3A11/1000SW (D12/292642)

**Shoalhaven Water Comments – Final Environmental Assessment  
MP10\_0240 for RMS - Princes Highway Upgrades - Fox Grounds & Berry  
Bypass**

I refer to your Final Environmental Assessment dated November 2012 in relation to the above noted project; Shoalhaven Water provides the following comments:

Figure 4-19 Major utilities within the project corridor

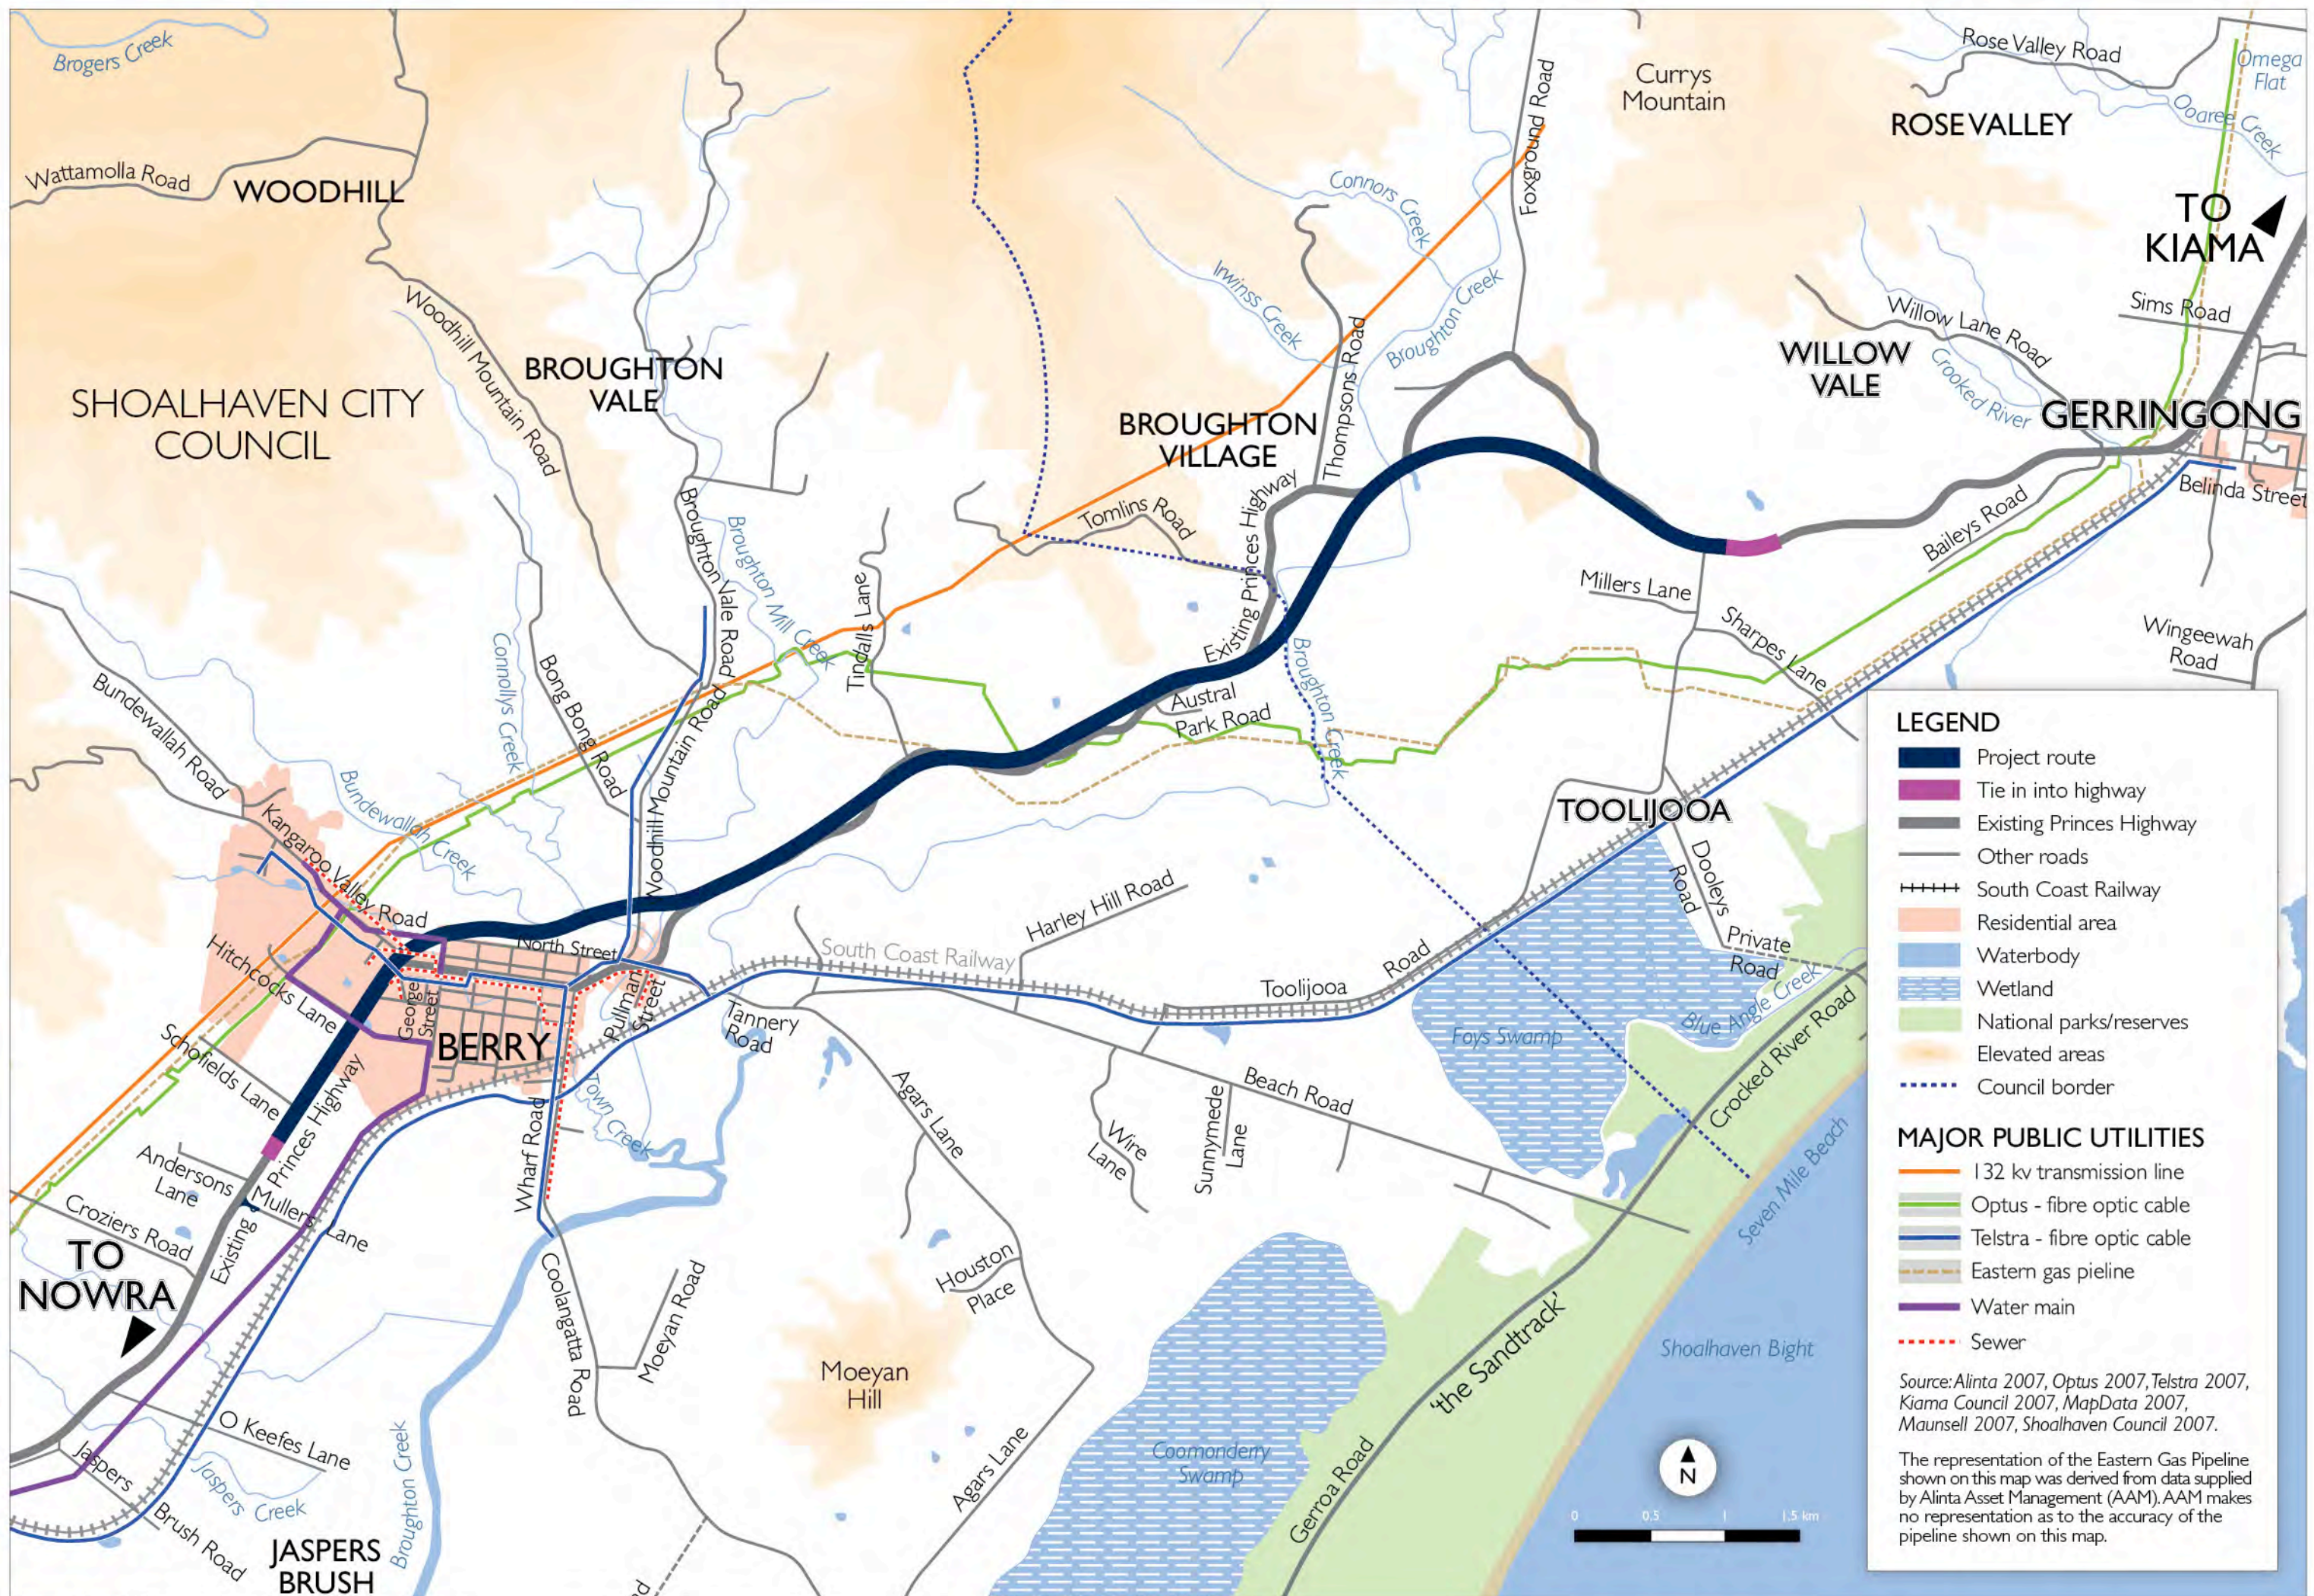
The proposed works appears to impact on the following assets and detailed investigation will be required to determine the impact and rectification measures.

No.	Description	Approx. Ch	Approx Location	Asset Status
	<b>WATER MAINS</b>			
1	100mm uPVC reticulated water main	15750	Nth Tannery Rd	
2	50mm uPVC reticulated water main	16000	Woodhill Mt Rd	
3	150mm AC/C trunk water main	17500	North St	<b>Critical</b>
4	200mm AC/C trunk water main	17500	North St	<b>Critical</b>
5	100mm mPVC & AC reticulated water main	17600	Kangaroo Valley Rd	
6	150mm DICL reticulated water main	18000	Victoria St	
7	195mm uPVC trunk water main	18200	Hitchcocks Lane	<b>Critical</b>
	<b>SEWER MAINS</b>			
8	225mm uPVC sewer main CV/8A to CV/8	17600	North of Kangaroo Valley Rd	<b>Critical</b>
9	150mm uPVC sewer main CX/4 to CX/3	17700	Huntingdale Pk Rd	
10	150mm uPVC sewer main 5A/7 to 5B/1	17900	Lincoln Close	
11	225mm uPVC sewer main 5A/6 to 5A/5	18000	Victoria St	<b>Critical</b>

- Shoalhaven Water has undertaken preliminary investigation into the deviation of gravity sewer lines which cross the proposed highway. It appears that subject to detailed investigation and design that diversion of the sewer from north of Kangaroo Valley Road may be achievable.

This redirection will increase the loading on the existing line 5B by approximately 104 ET's. This increase loading may have an impact on the downstream sewer pumping station and rising main (Pumping Station 5 & Rising main 5). Therefore the applicant will be required to undertake assessment of the capacity changes to the rising main and pumping station as a result of any deviations.

- **Shoalhaven Water does not approve concrete encasement of AC water mains. Any AC water main affected by the proposed works will need to be replaced in accordance with Shoalhaven Water's standards.**

Sewer and Water assets are not approved to be located under road pavements other than road crossings. Any approved assets (by Shoalhaven Water) proposed to be located under pavements will require to be relocated at the applicant/developer's expense.
